OXFORDSHIRE COUNTY COUNCIL'S RESPONSE TO CONSULTATION ON THE FOLLOWING DEVELOPMENT PROPOSAL

Application no: 16/01805/F-3

Proposal: Change of use of buildings from sui generis MOD use to various commercial uses as detailed in accompanying Planning Statement with associated physical works and demolition of buildings 101 and 104 and erection of replacement structures

Location: Bicester Heritage, Buckingham Road, Bicester OX26 5HA.

Figure 1: Bus stops indicated in red at site entrance

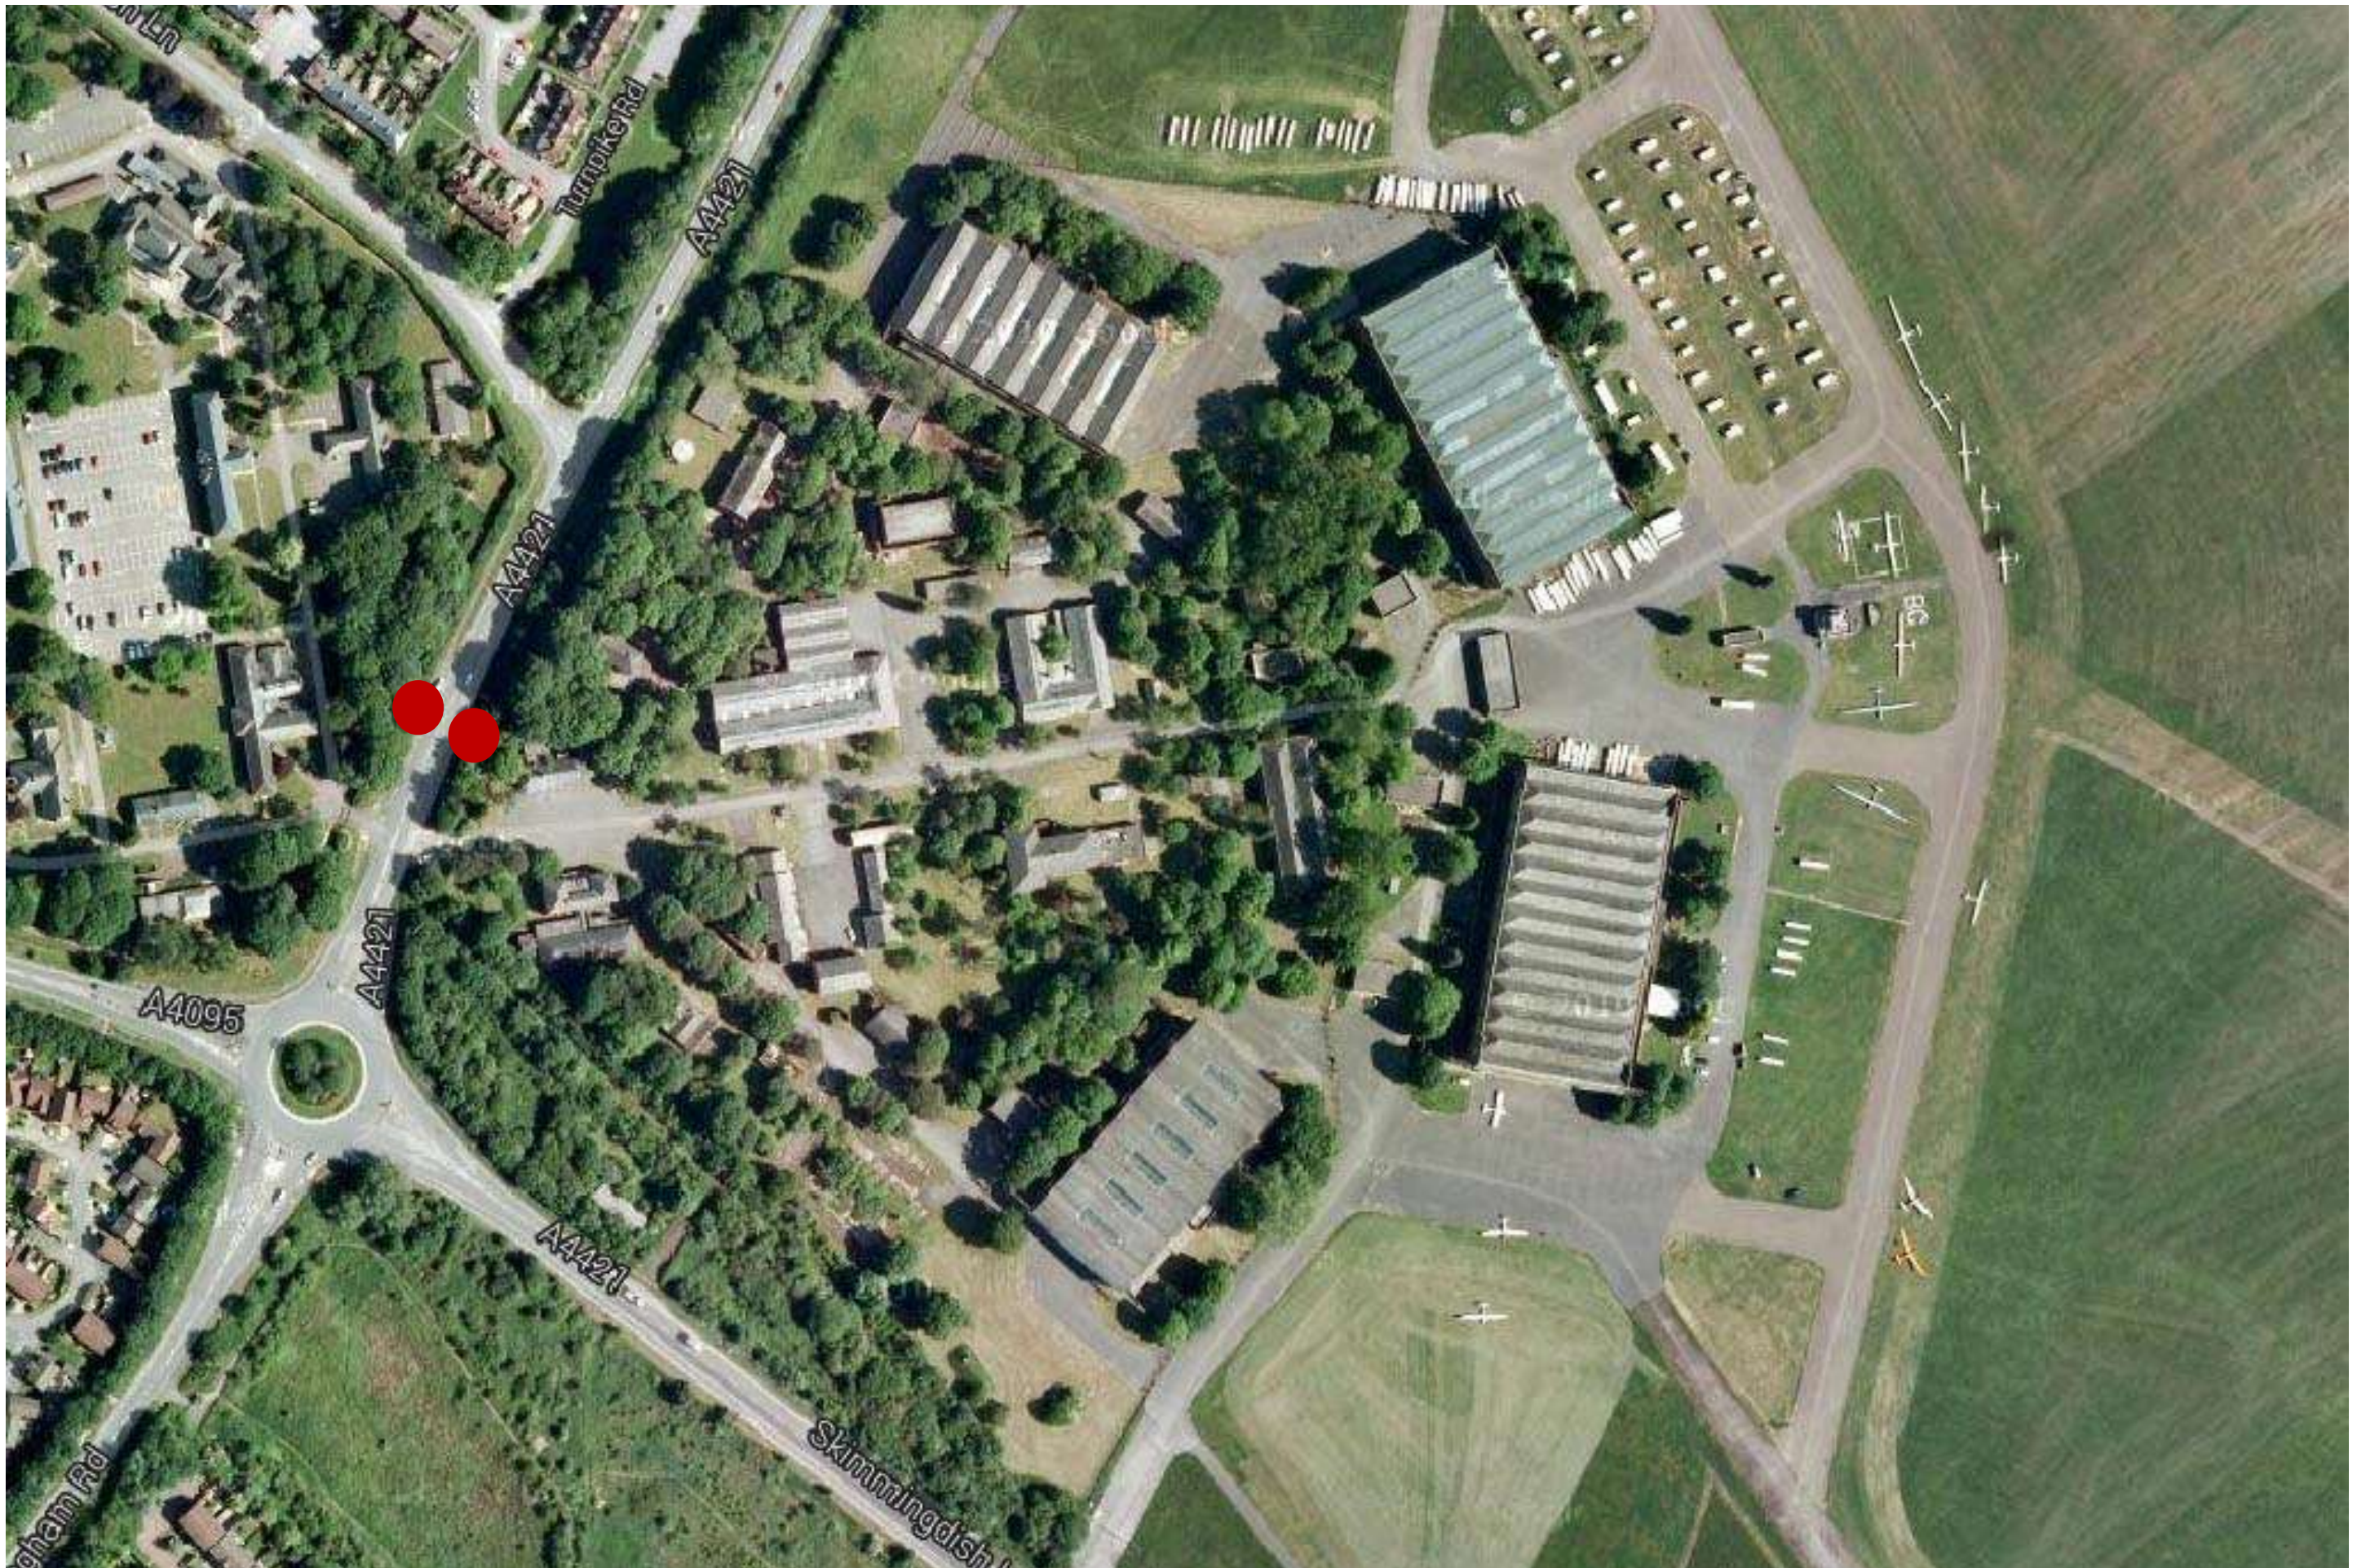
- The applicant has not demonstrated safe and suitable access for all. Whilst there are reasonable pedestrian and cycling facilities in the vicinity of the development, there is no safe and convenient way for people to get to them from the main access of the development on the Buckingham Road. Pedestrians cannot conveniently and safely get to and from the nearby pair of bus stops on the Buckingham Road. A crossing of Buckingham Road will need to be provided.

However, there is no safe and convenient way to gain access to any of these walking and cycling facilities. This is because there is no footway/cycleway at or leading to the site access on Buckingham Road and there is no crossing to help people get across this very busy road. As such this proposal neither allows for safe and suitable access for all nor does it ensure that opportunities for sustainable transport modes have been taken up – despite the fact that the site is in a location close to a significant population which suggests walking and cycling should be realistic options for people to travel there.

The provision of a crossing of Buckingham Road would double up as a way for people travelling to the site by bus to do so safely. Together with this crossing, a footway leading to/from the southbound bus stop will ensure that using the bus to get to and from this development becomes not just a safer but also a much more attractive proposition – very much more in line with the intentions of the NPPF, specifically paragraphs 32 and 35.

If Cherwell District Council is minded to grant planning permission, a S278 would be needed to provide an improved site access to include pedestrian provision at the access itself and

also to ensure pedestrians and cyclists can access the nearby footways, cycleways and bus stops i.e. footway extension/improvements and a crossing of Buckingham Road.
